Planning Department

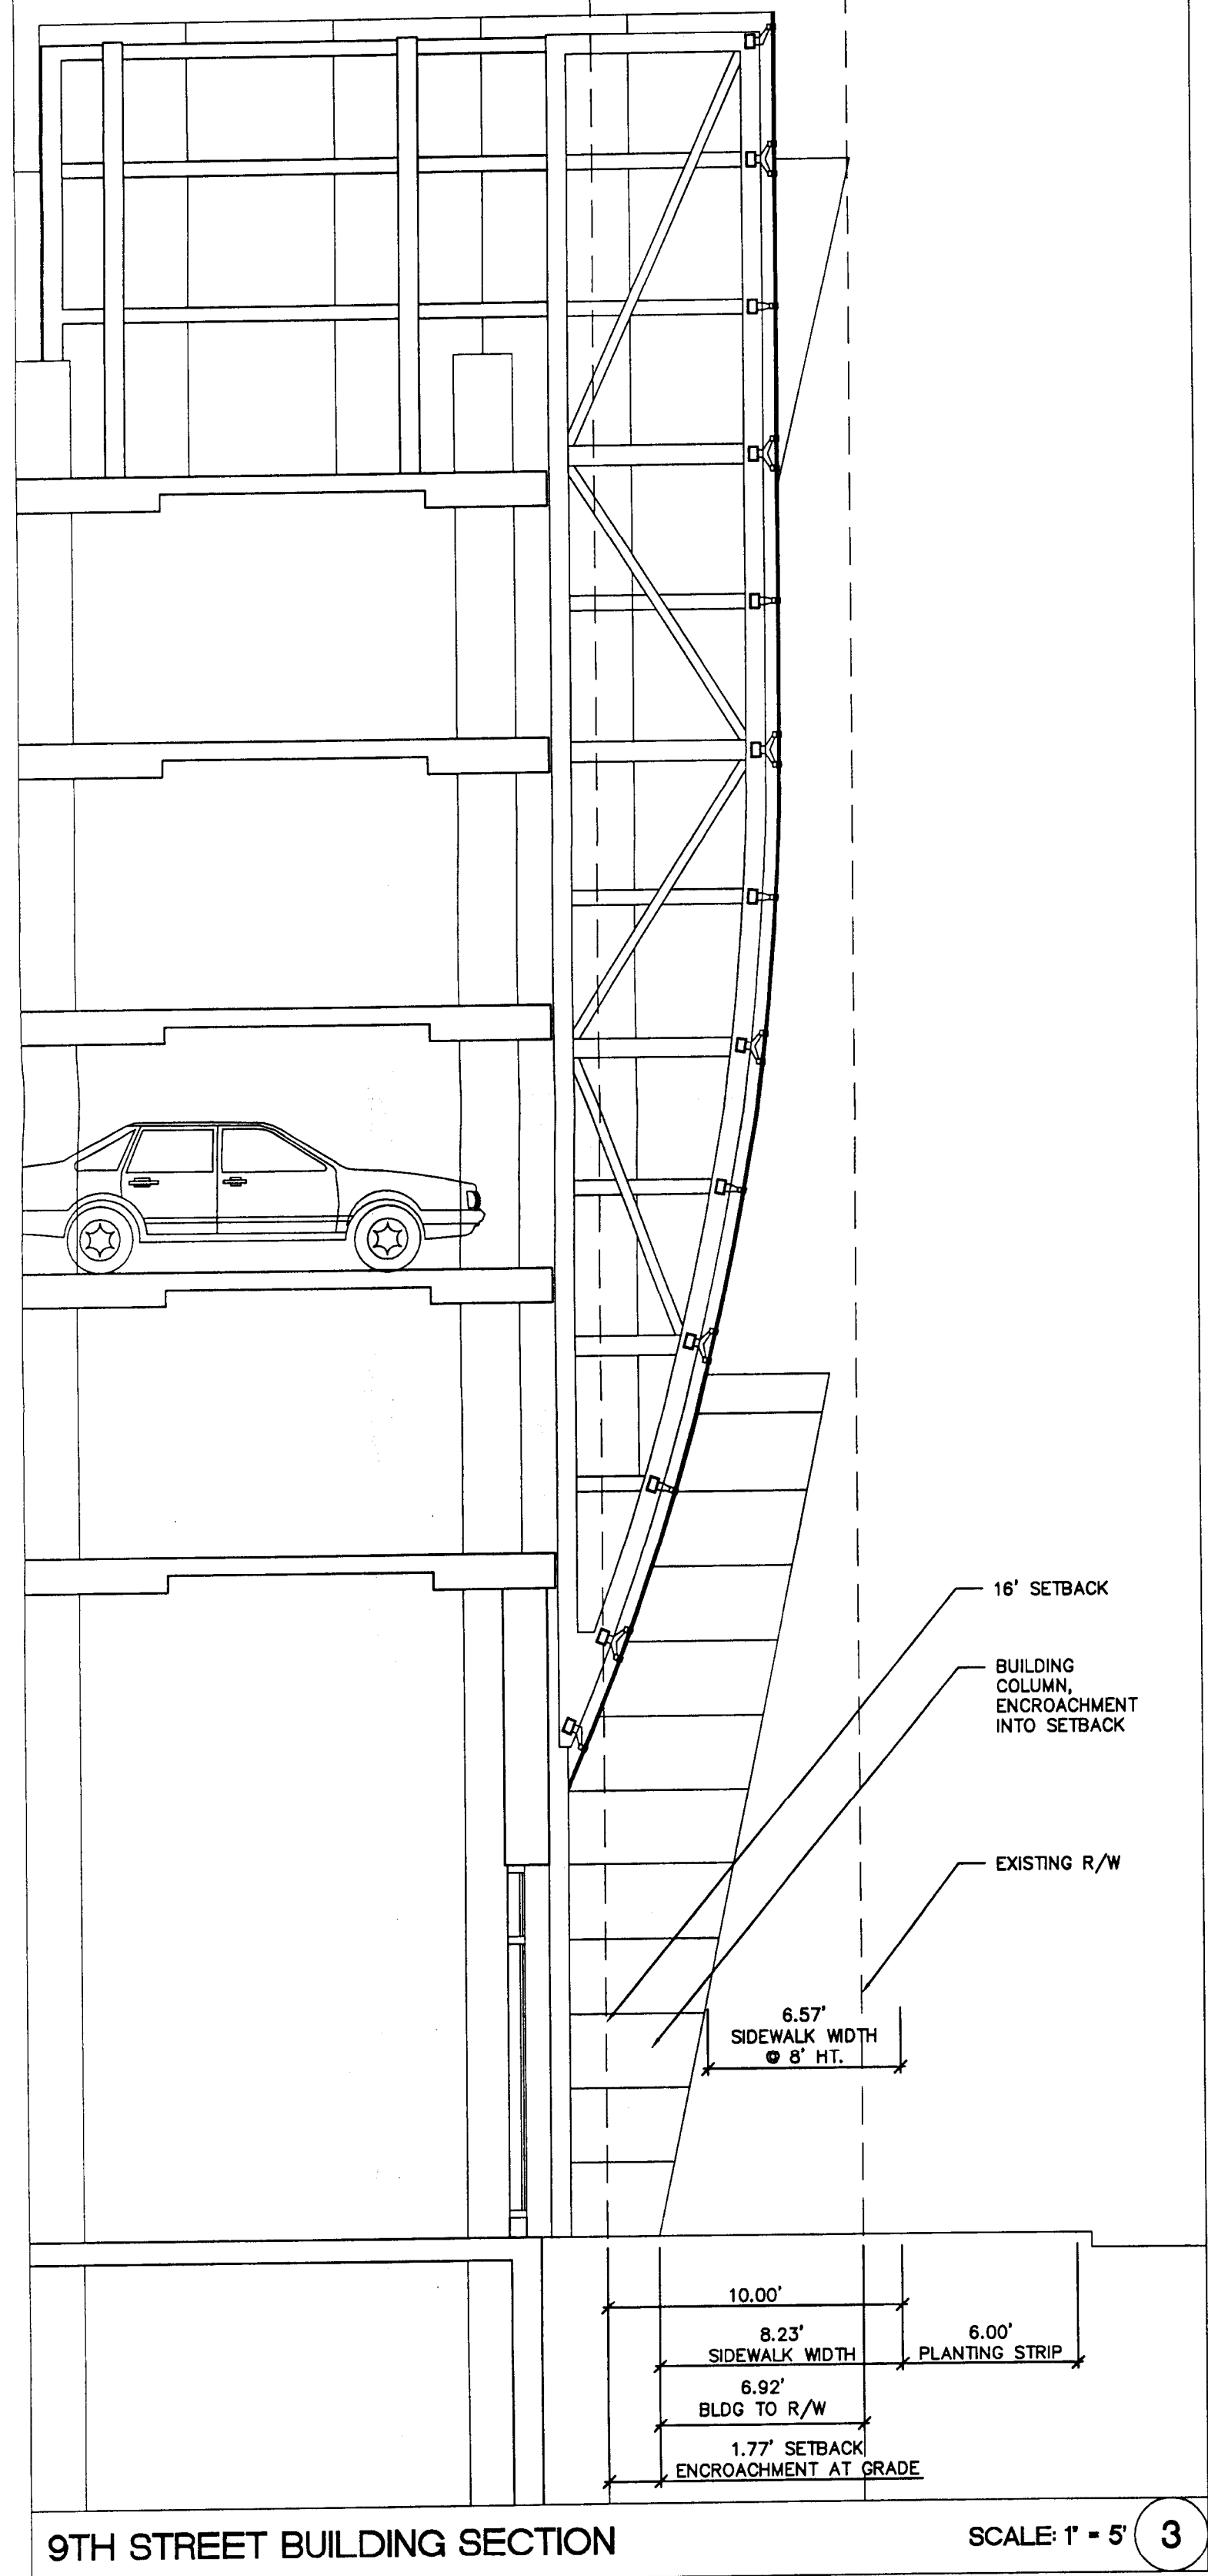
1. ~~Entitlement Services: Add rezoning petition number to site plan.~~ Addressed
-
